A47/A11 Thickthorn Junction

Scheme Number: TR010037

Volume 9 **9.15 Environmental Statement Addendum**

ENVIRONMENTAL STATEMENT ADDENDUM

Drawing Number Highways England PIN HE551492- GTY-LLO-000-DR-BL-30013	Rev P01
--	-------------------

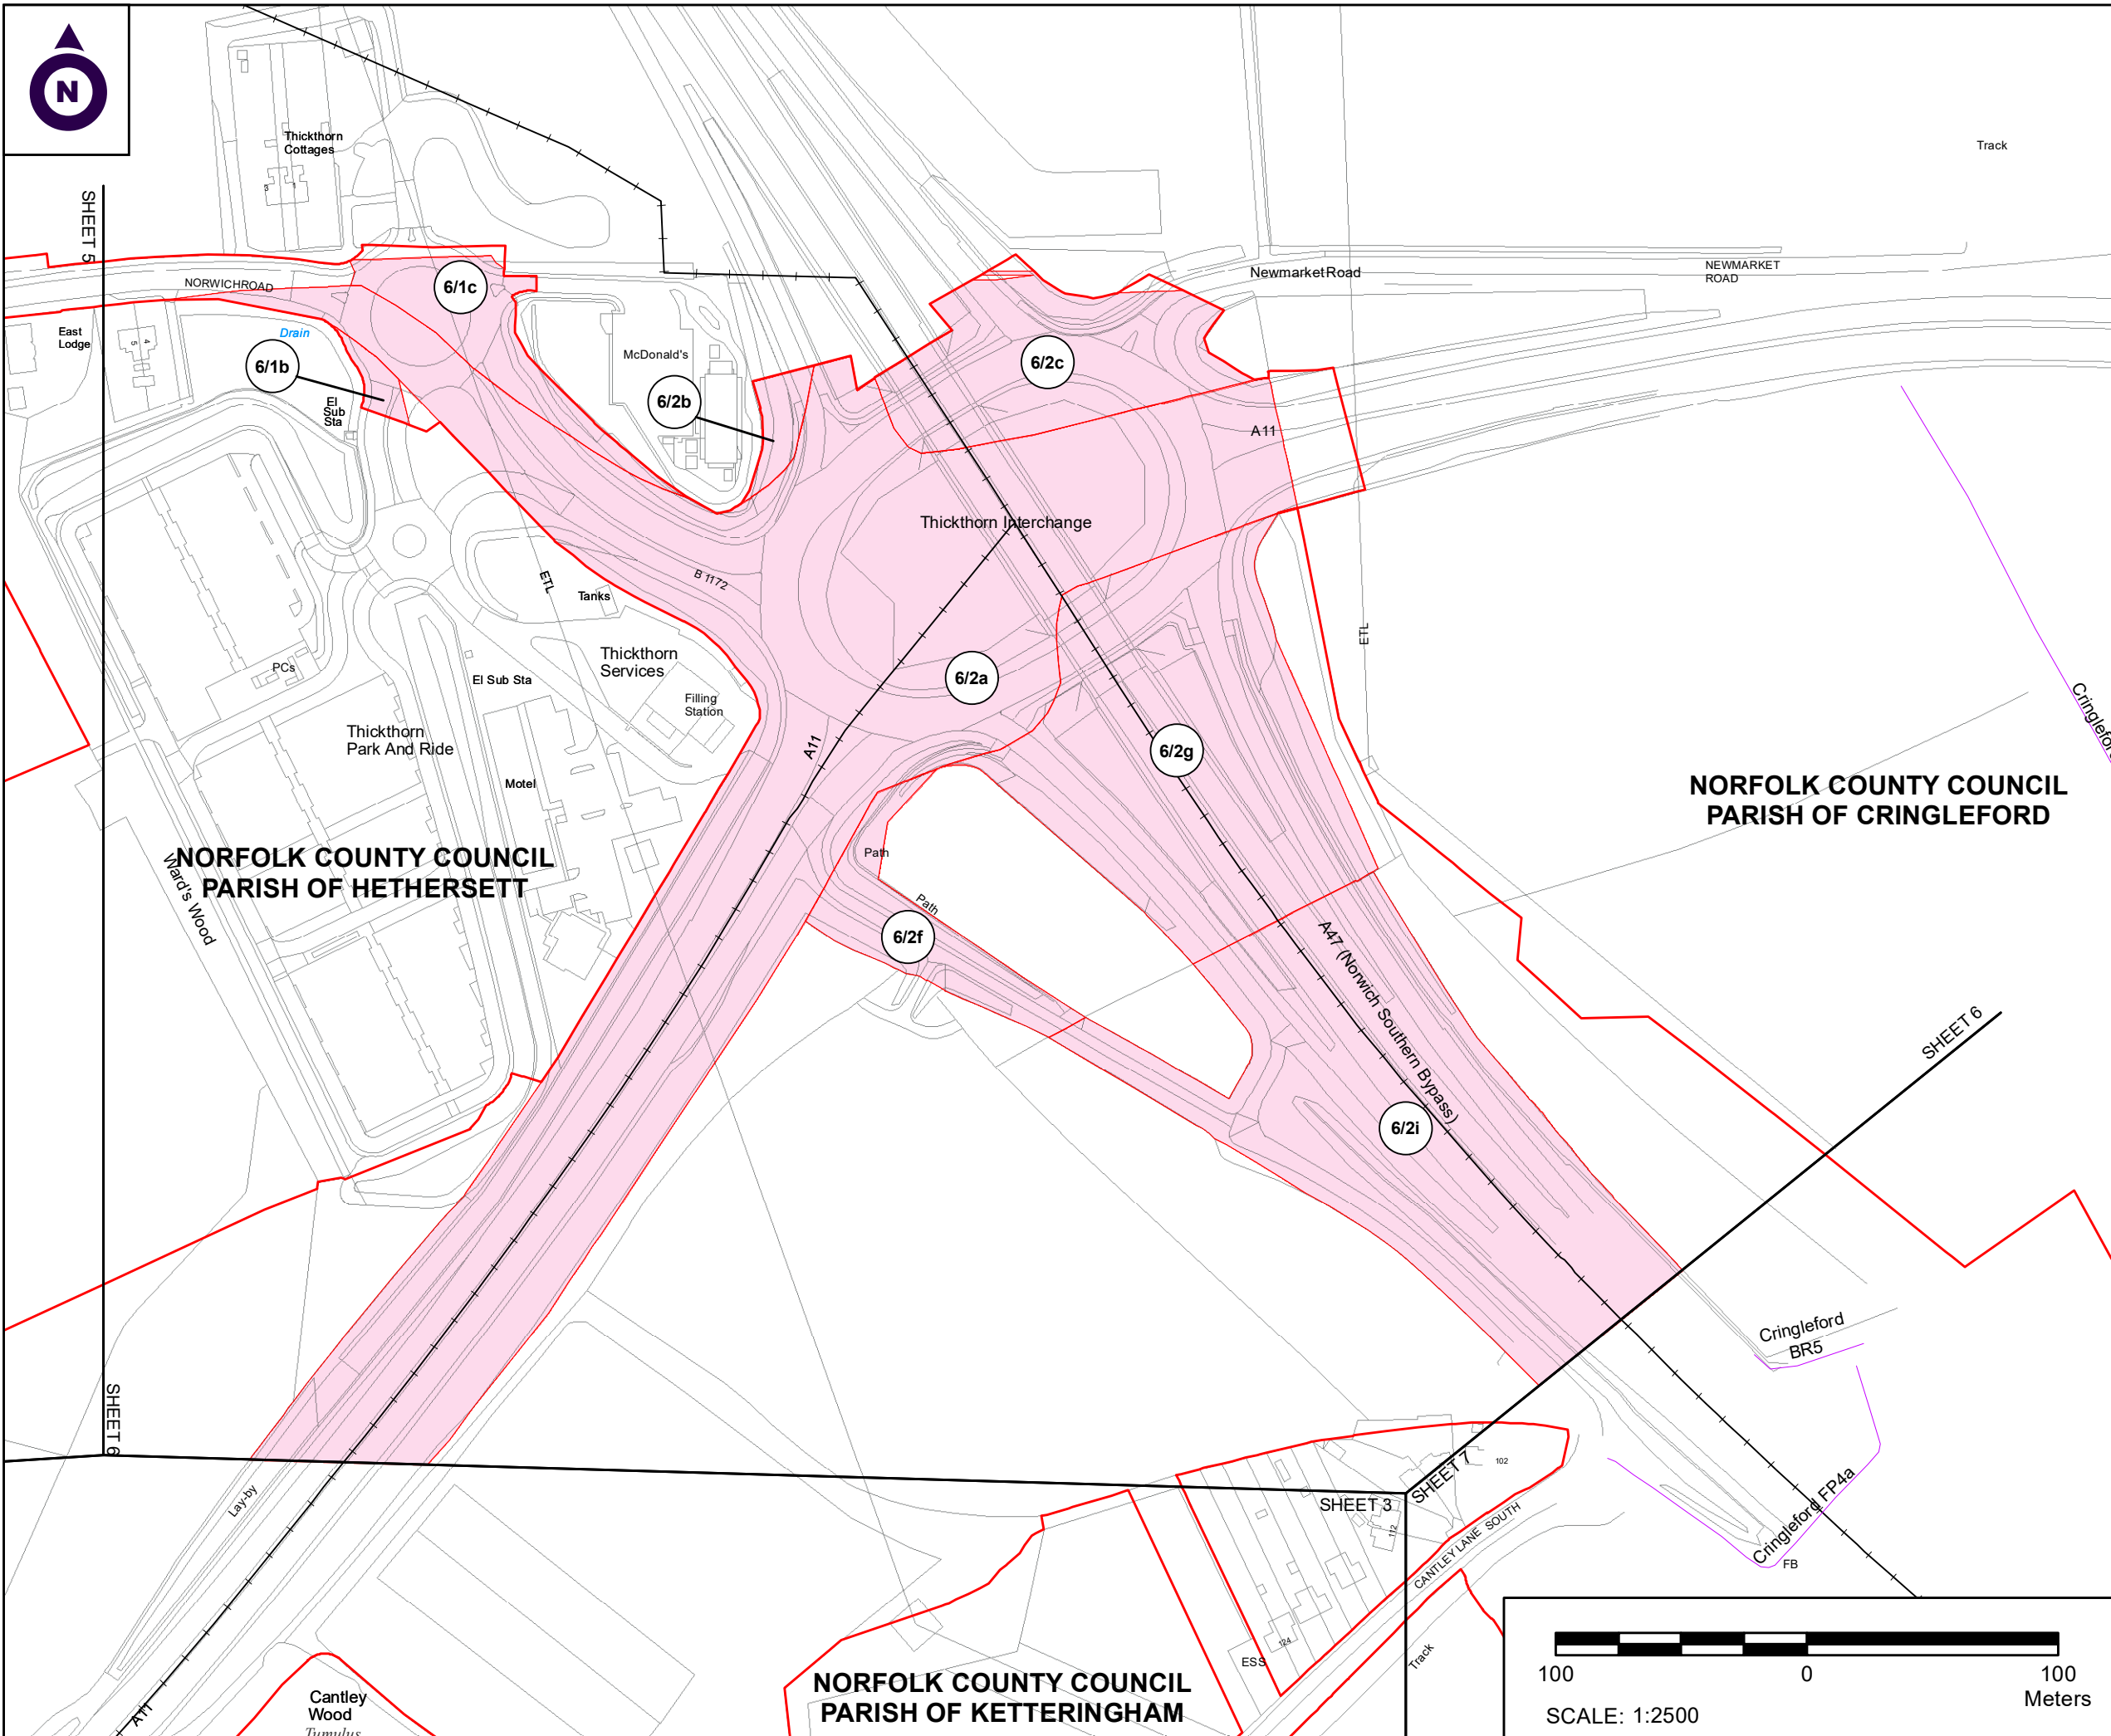
- 2.1.1 A property on Intwood Road adjacent to the Cantley Stream was included in the current Order Limits as initial flood modelling indicated an increased detriment in flood levels at the property that could require local mitigation measures. This is shown as Plot 7/12a on the Land Plans (**APP-006**).
- 2.1.2 Between the DCO application submission in March 2021 and the examination, additional survey information obtained and used to update the flood model, showed no increased detriment to flood levels at the property. No mitigation is subsequently required. The Applicant is proposing that Plot 7/12a can therefore be removed from the Order Limits. The updated Flood Risk Assessment was submitted to the Examining Authority at Deadline 3 (**REP3-008**).
- 2.1.3 The revised Order Limit is shown on Figure 1.1 (**APP-053**).

Drawing Number: HE551492-GTY-LLO-000-DR-BL-30006	Rev: P04
--	----------

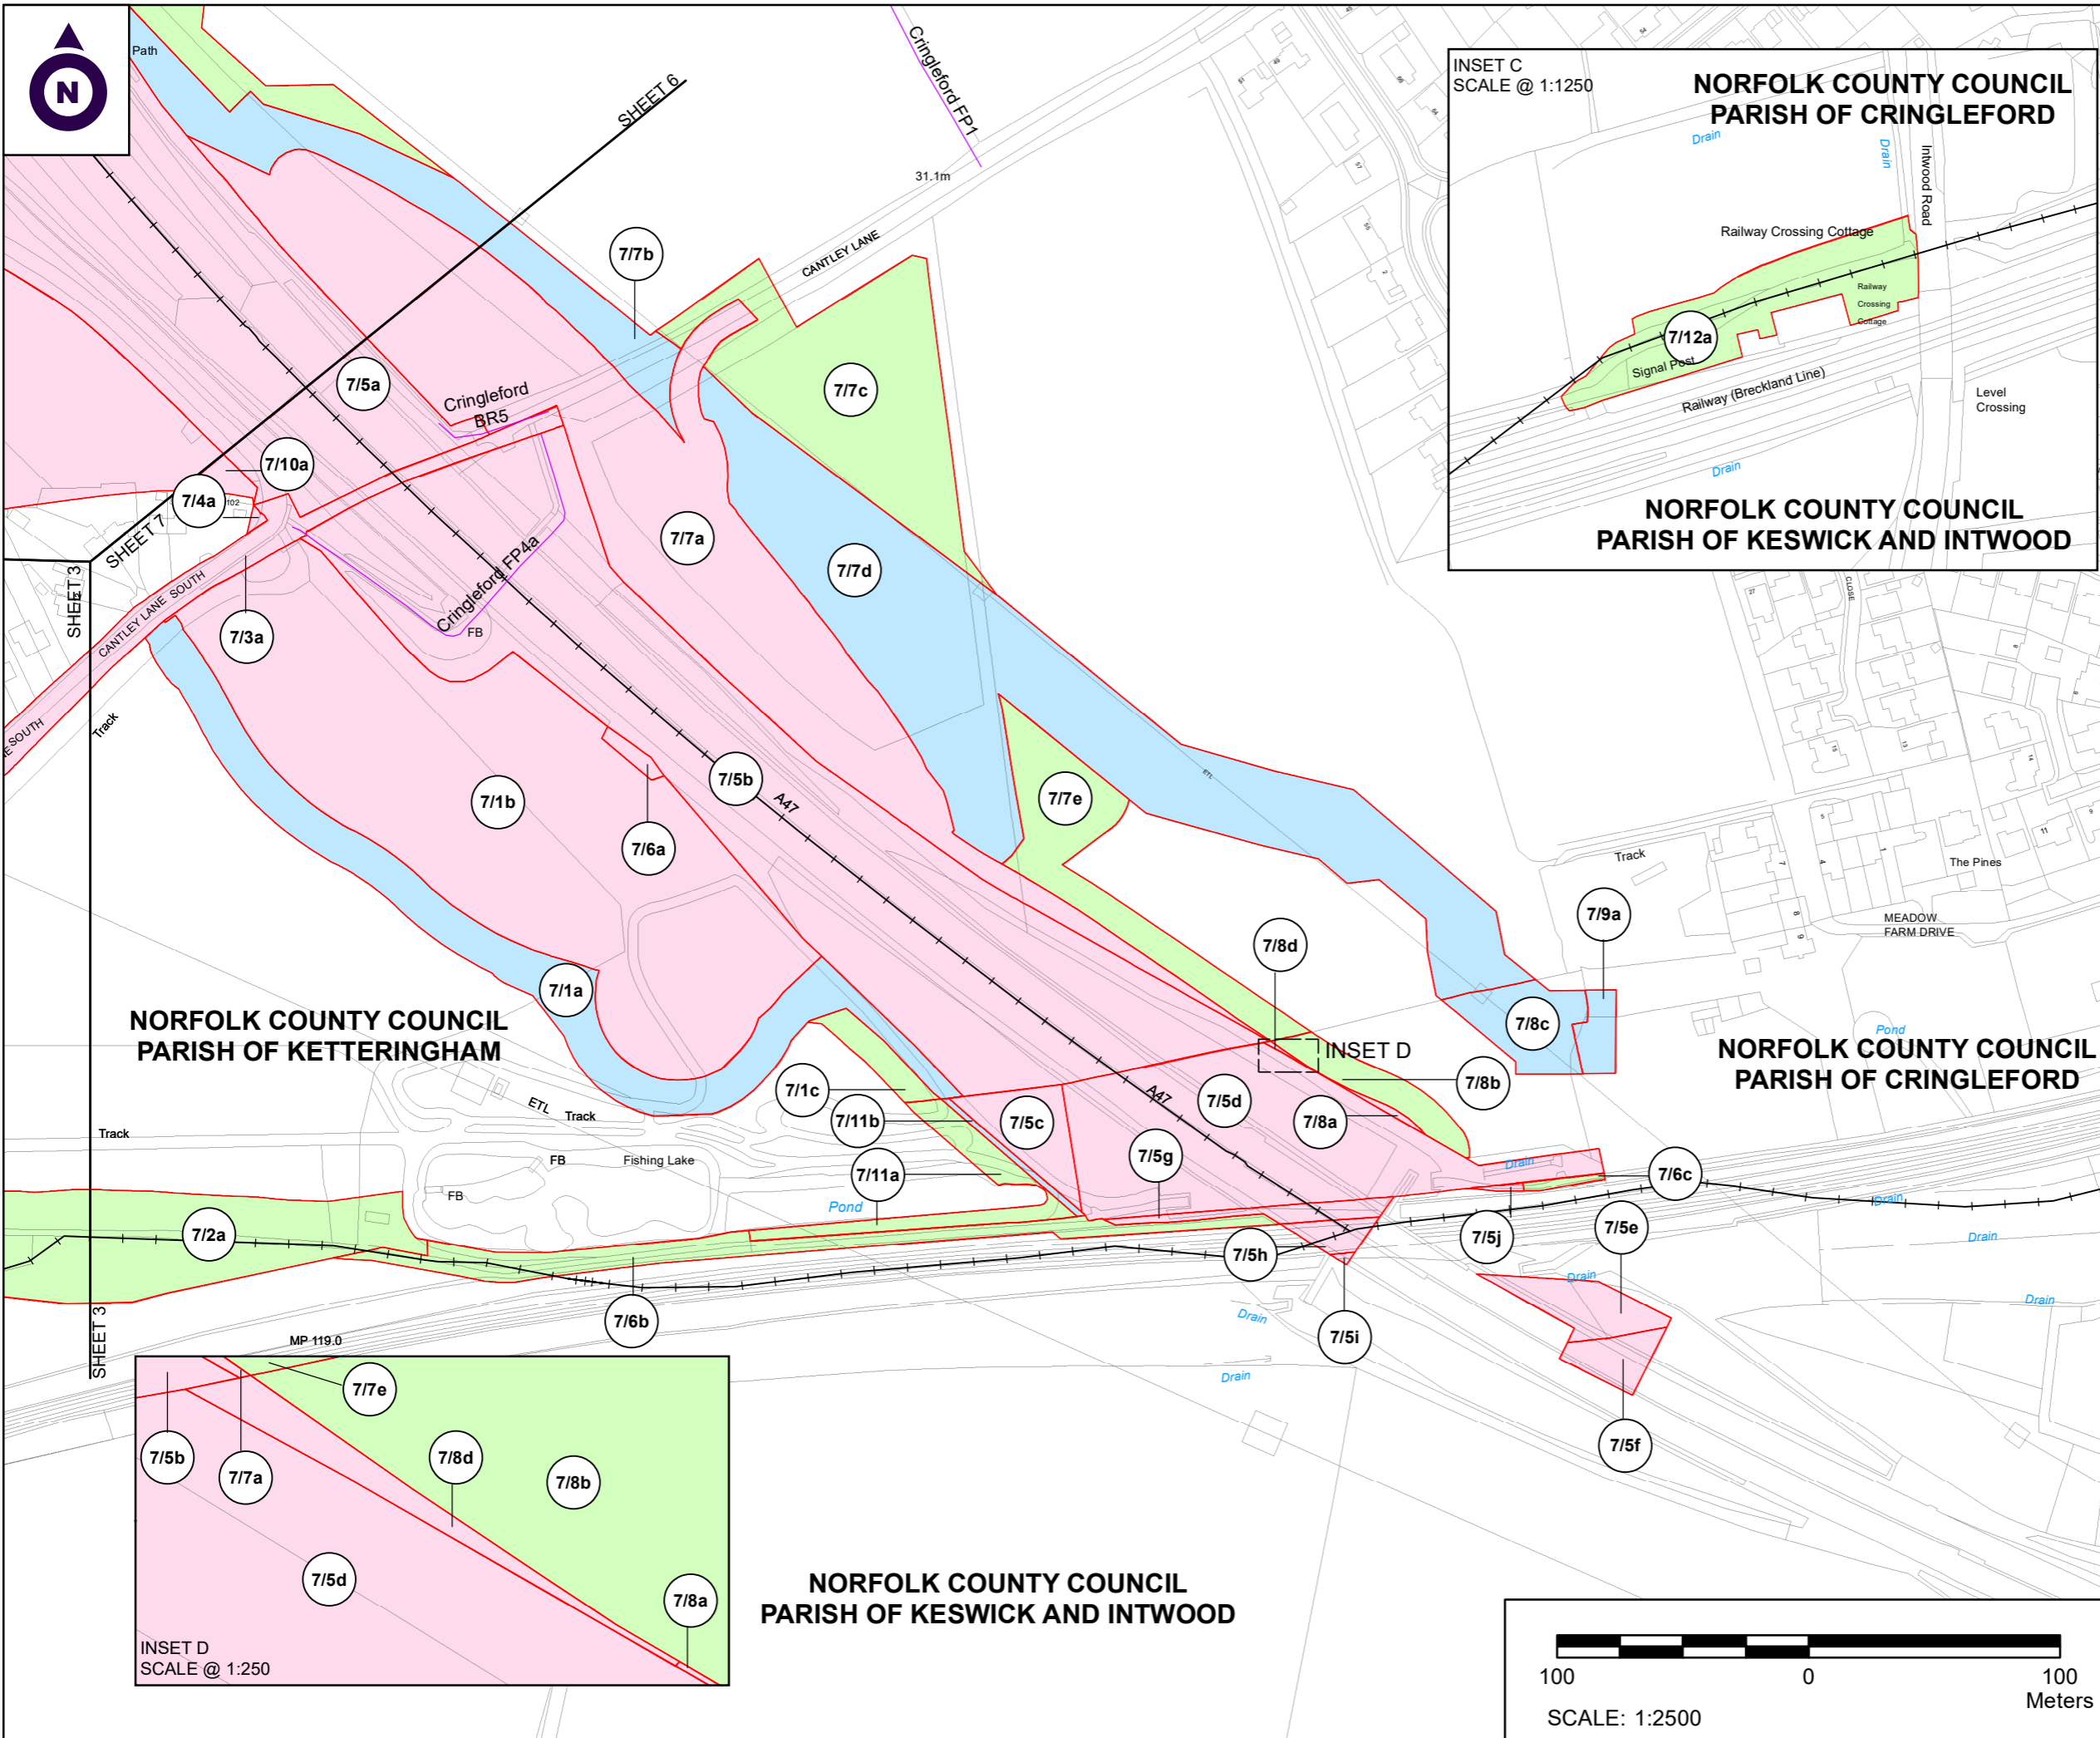
- 3.2.2 As a result of a detailed review into the method of construction undertaken by the Applicant, a reduction in the cross section of the Cantley Lane Underpass (S04) can be achieved by adjusting the horizontal alignment of the A11-A47 Link Road between the Wards Wood Underpass and the Cantley Lane Underpass to reduce the width of the offside verge required to accommodate forward visibility. The maximum deviation from the current alignment is 7m horizontally to the north.

- 3.2.3 The proposed amendment to the horizontal alignment will require a corresponding adjustment to the earthwork cut slopes required for the A11-A47 Link Road and the bunding provided north and south.

- 3.2.4 This design change is shown on the General Arrangement Plans, Rev.1 (**APP-005**) submitted at Deadline 4.
- 3.2.5 The Applicant considers this proposed change to be non-material, as the design changes remain within the limits of the land to be permanently acquired by the Applicant as shown on Sheet 6 of 7 of the Land Plans (**APP-006**). This design change also remains within the highway works limit of deviation as shown on Sheet 6 of 7 of the Works Plans (**APP-007**). There are no other changes to permanent or temporary land take as a result of this design change.
